**From:** David McRae  
**Sent:** Friday, April 26, 2019 4:10 PM  
**To:** 'Debra Landell'  
**Subject:** Dollar General - 72 Spring Hill Church Road - Sign Application

Good afternoon. I have reviewed the Spring Hill Church Road Dollar General sign application (SIGN1904-0007). The initial review was disapproved. Please see below for comments on a few items that need to be addressed.

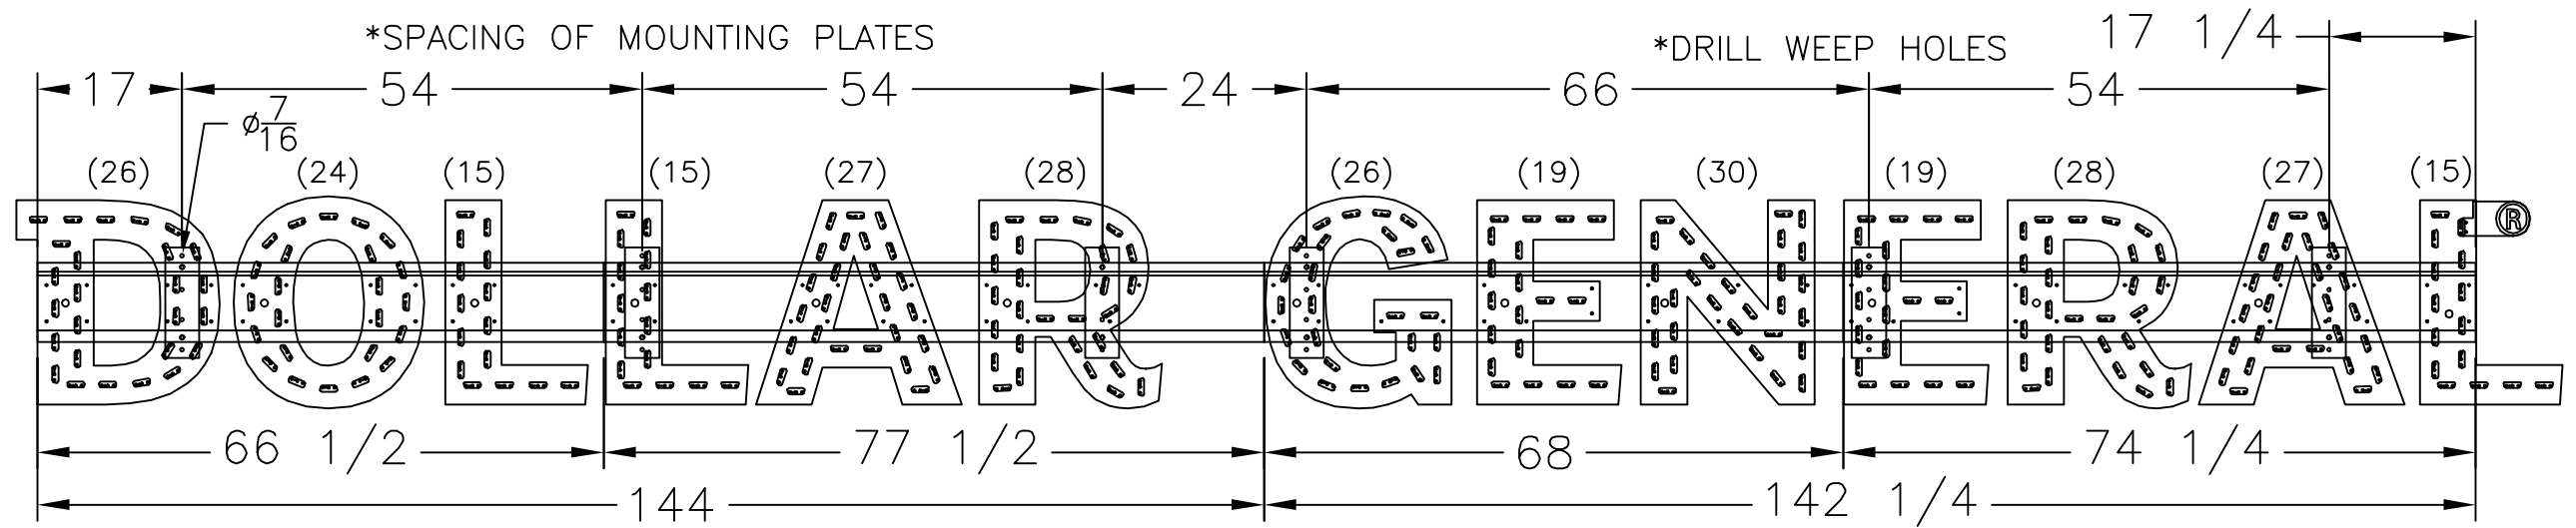
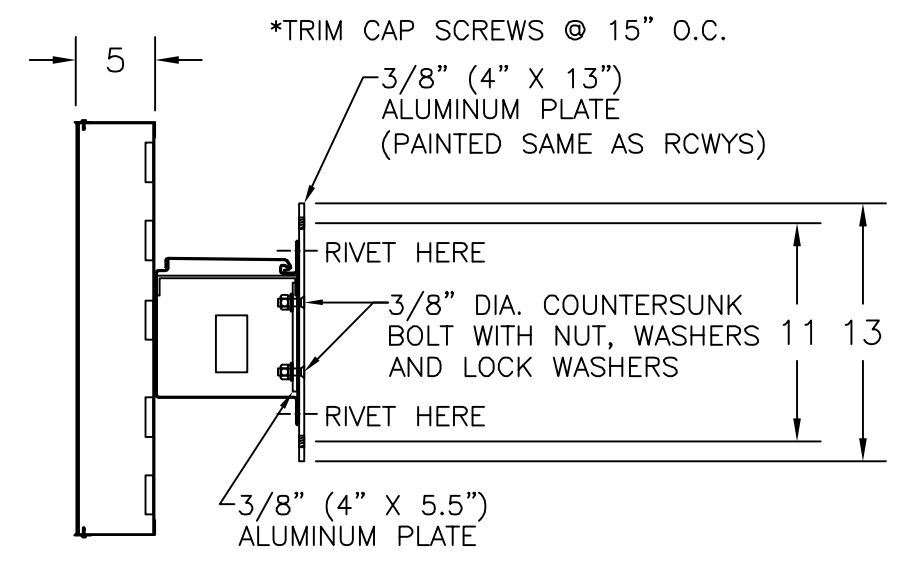
**South Elevation** – This building frontage is only 55 feet wide. Therefore a maximum of 55 square feet of signage is allowed on this side of the building.

The proposed sign is 97 sq. ft.
